02/10/2020

**Darlington Public School Redevelopment (SSD-9914)
Request for Additional Information**

01 SECTION  
1:500

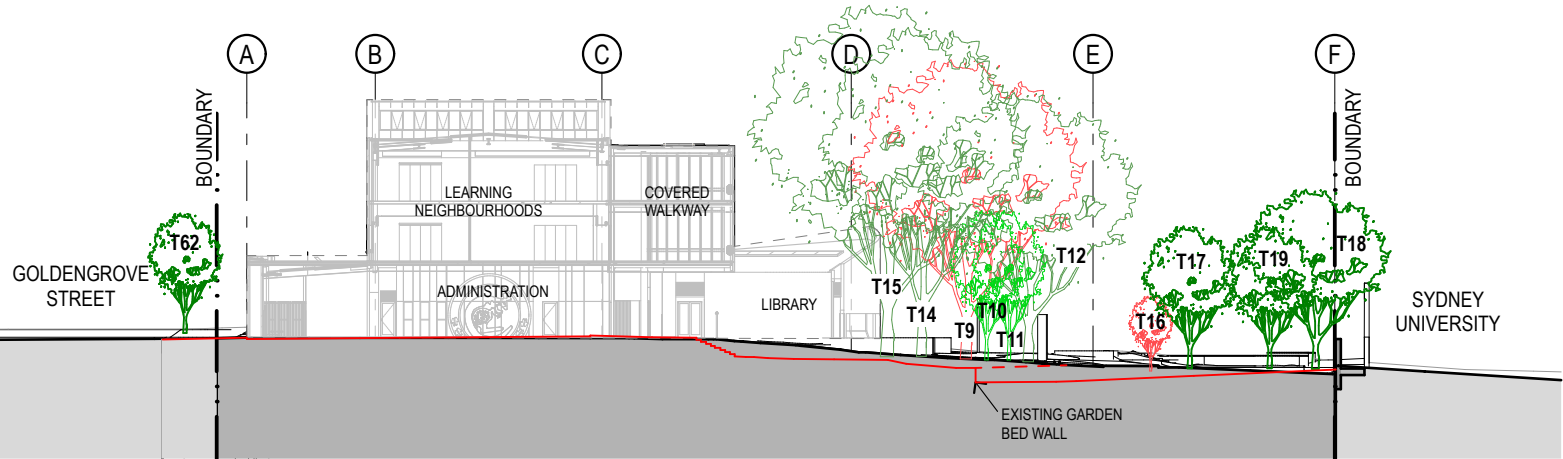
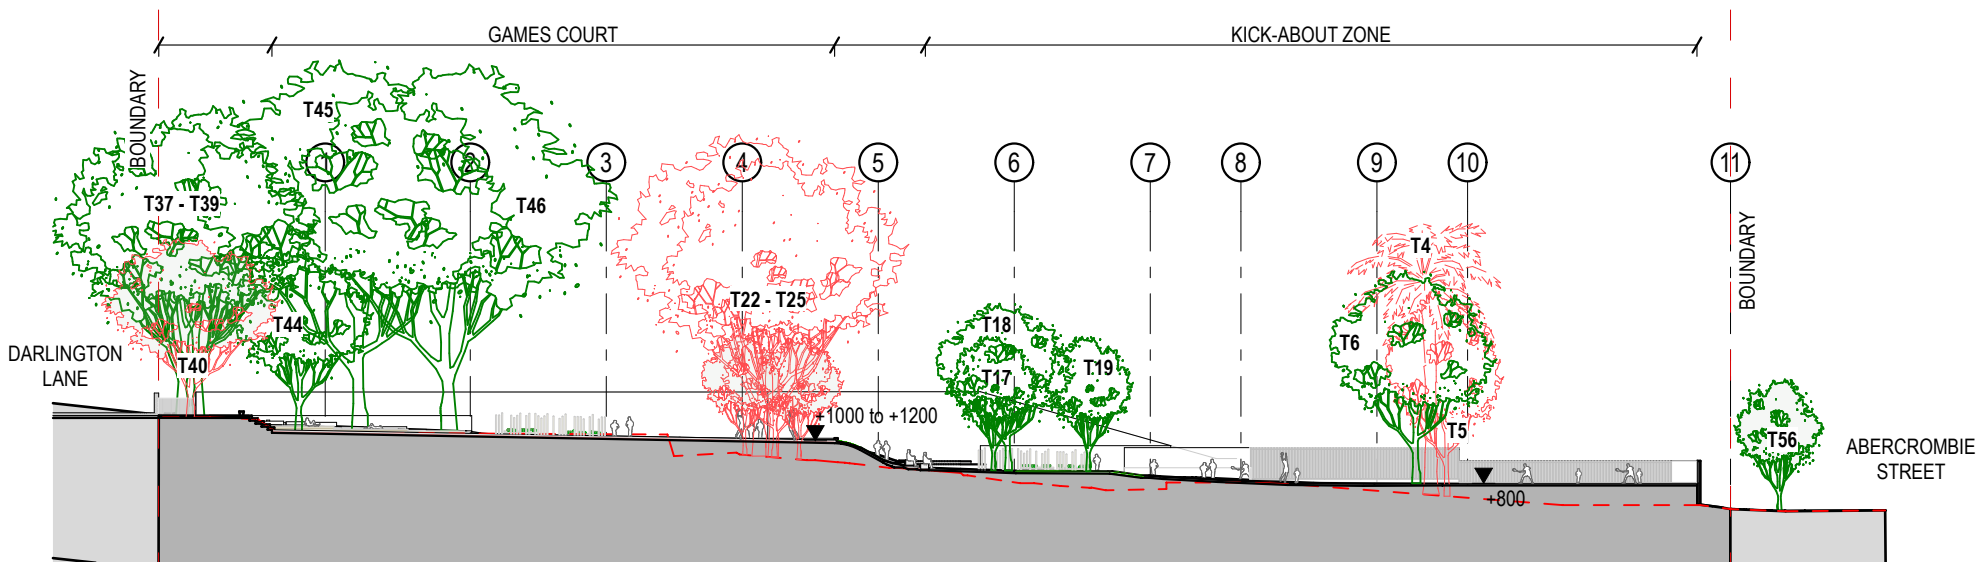
- Amended landscape plans which retain existing trees wherever possible. Plans should be made based on root mapping and exploration of piling and hand excavation methods. Levels should be resolved to retain existing trees in outdoor play areas.
- An amended tree canopy plan which calculates canopy on the site to reflect additional retained trees.
- A full and complete Arboricultural Impact Assessment Report prepared by a qualified AQF Level 5 Arborist that includes all trees on the site (including within and without the SSD application boundary) and consider the cumulative impact of all tree removal proposed, including as part of other development intended to be undertaken on the site.
